Development Facilitation Team (DFT) – Review Comments

Project No: PR-2024-010883 Date: 11/13/2024 Agenda Item: #2 Zone Atlas Page: H-13

Legal Description: Tract 1, Lands of Accion New Mexico

Application For: SD-2024-00156 – PRELIMINARY/FINAL PLAT

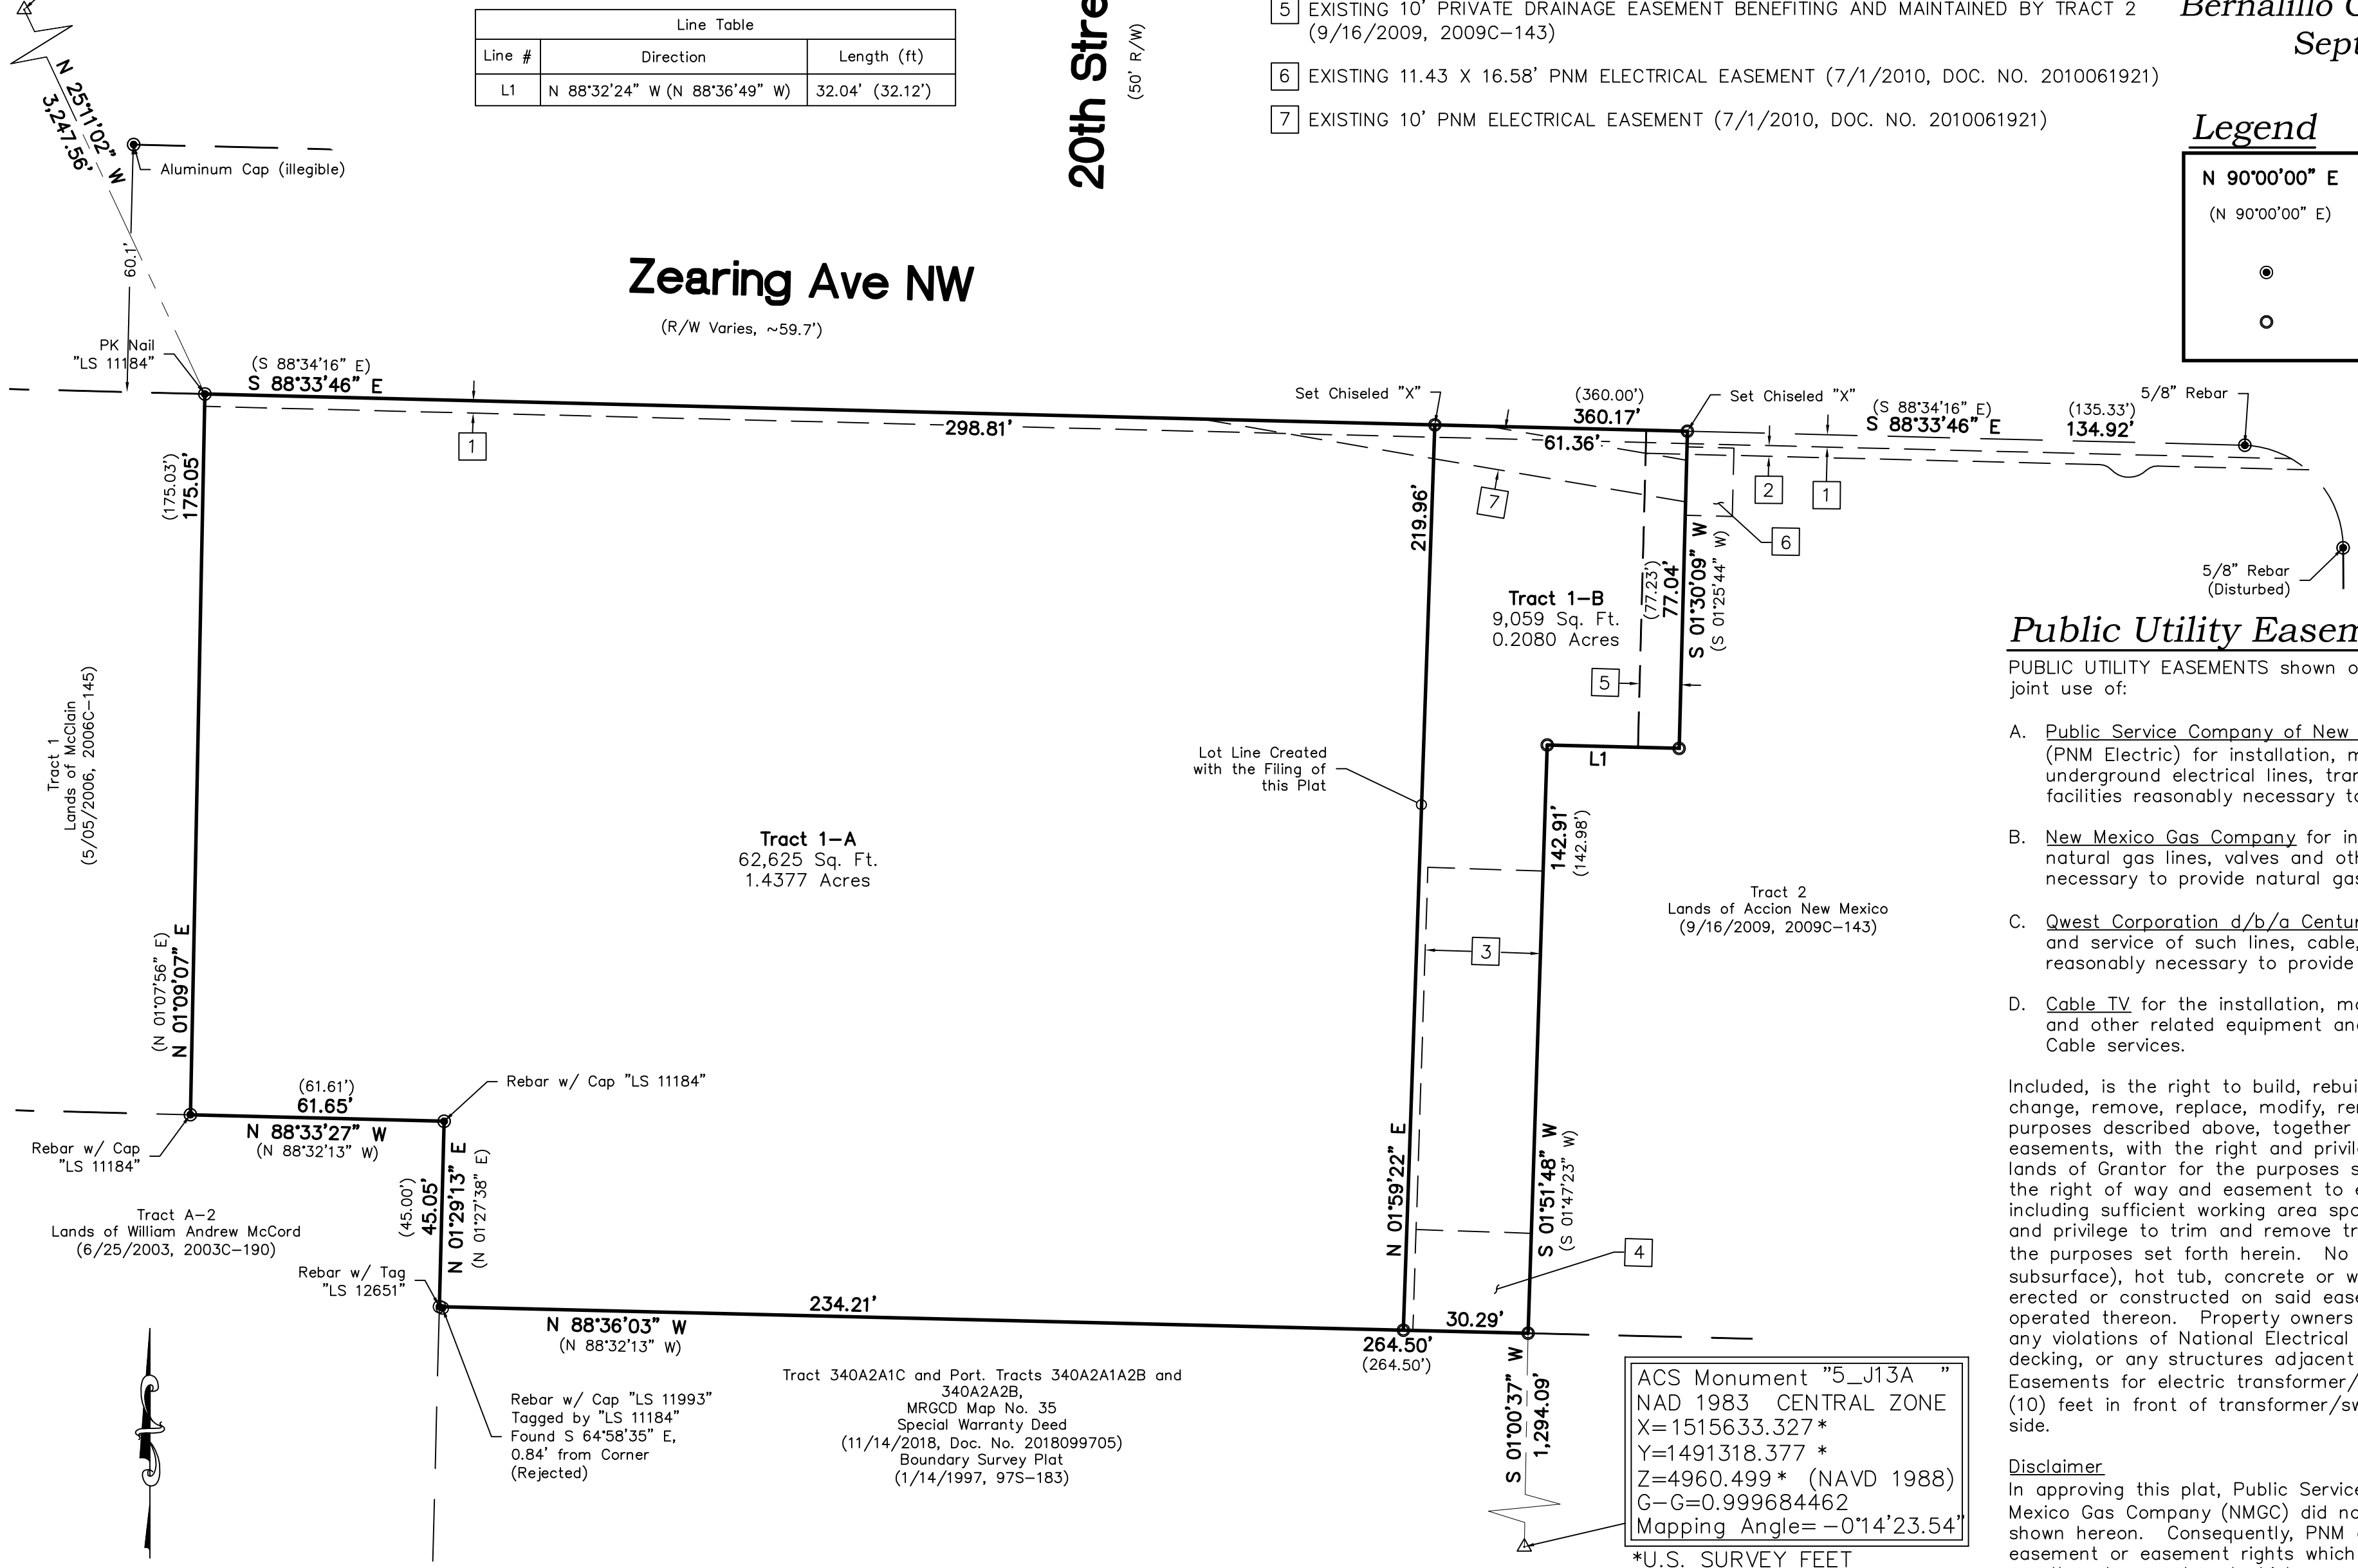
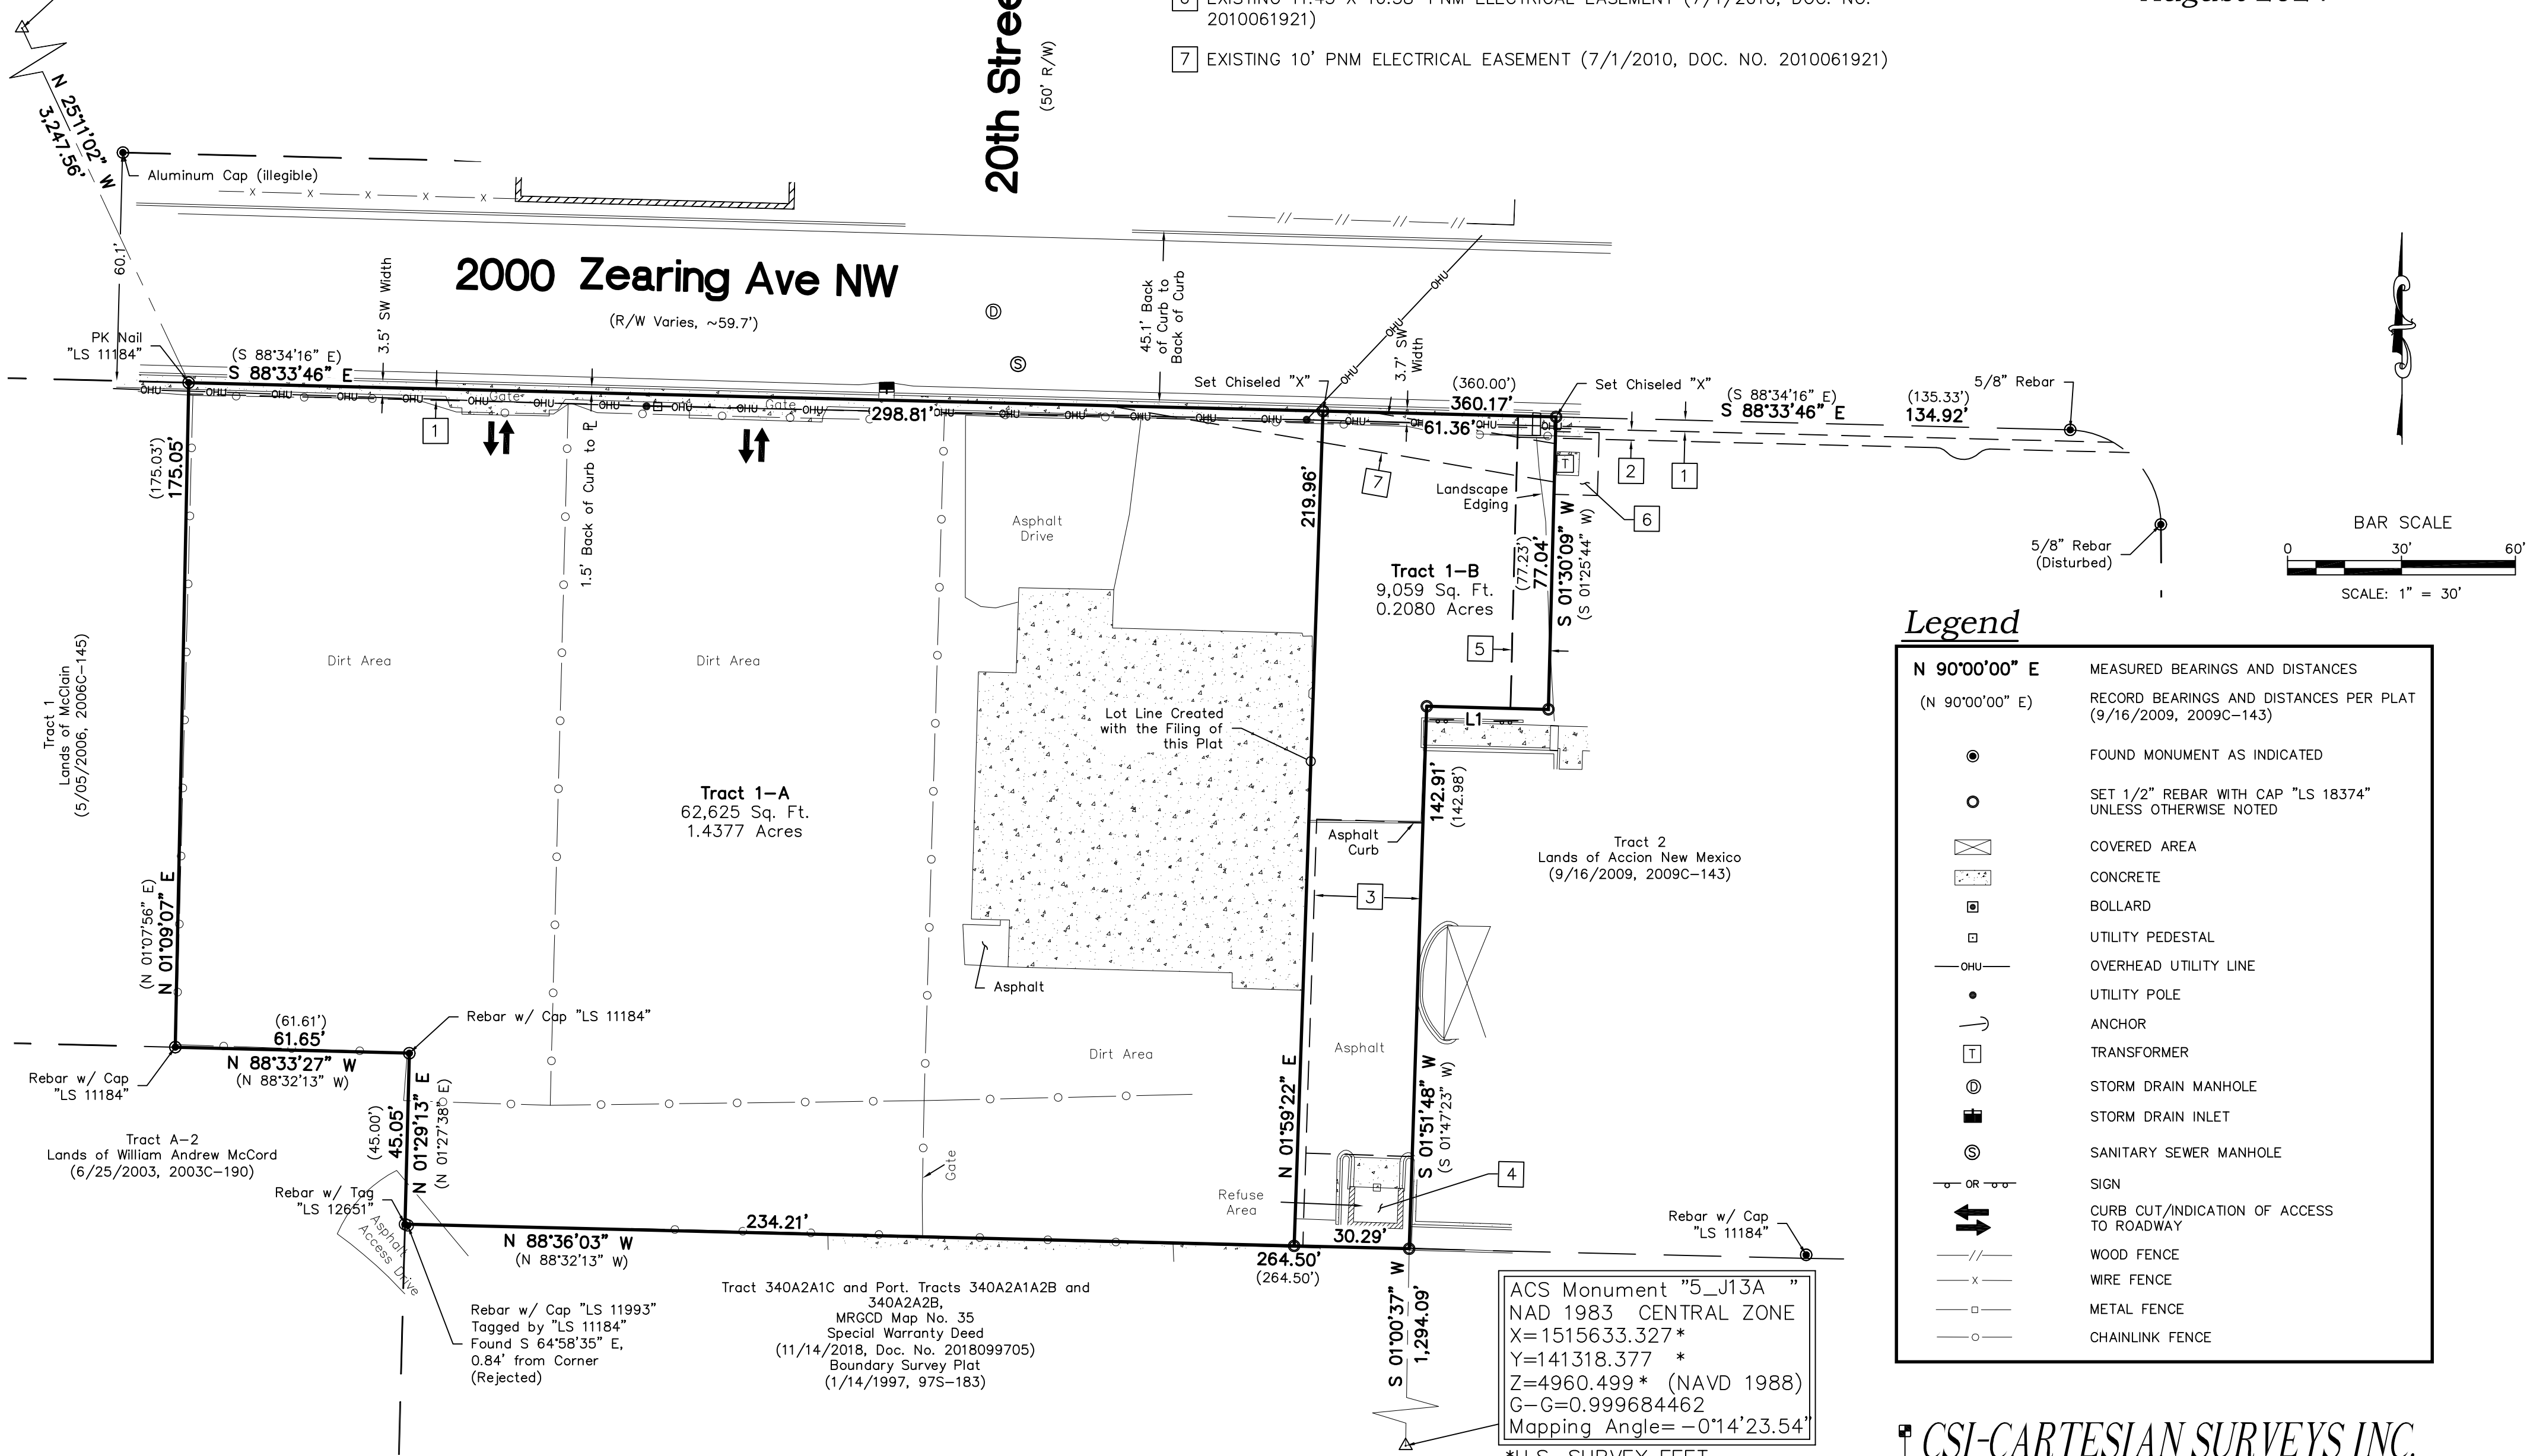
- **Demonstrate compliance with Section 7 of the DPM, Table 7.2.29, regarding Sidewalk width requirements and its landscape buffer.**

The subject property is not located within a Premium Transit Corridor or an Urban Center. Both Zearing Ave NW and 19th St. NW are local roads and require 5' sidewalks with 4' to 6' landscape buffers.

Per Section 3-4(M)(5)(a)(2) of the IDO relating to Sawmill/Wells Park CPO-12 requirements, an opaque wall or fence at least 6' in height with a 10' Landscape buffer would be required to screen non-residential use from adjacent residential lots across Zearing Ave. from the subject property. Please explain the current use of the concrete pad located on the site and if it is intended for parking purposes.

Applicant has included an Infrastructure List covering the widening of the sidewalk along Zearing with the application packet.
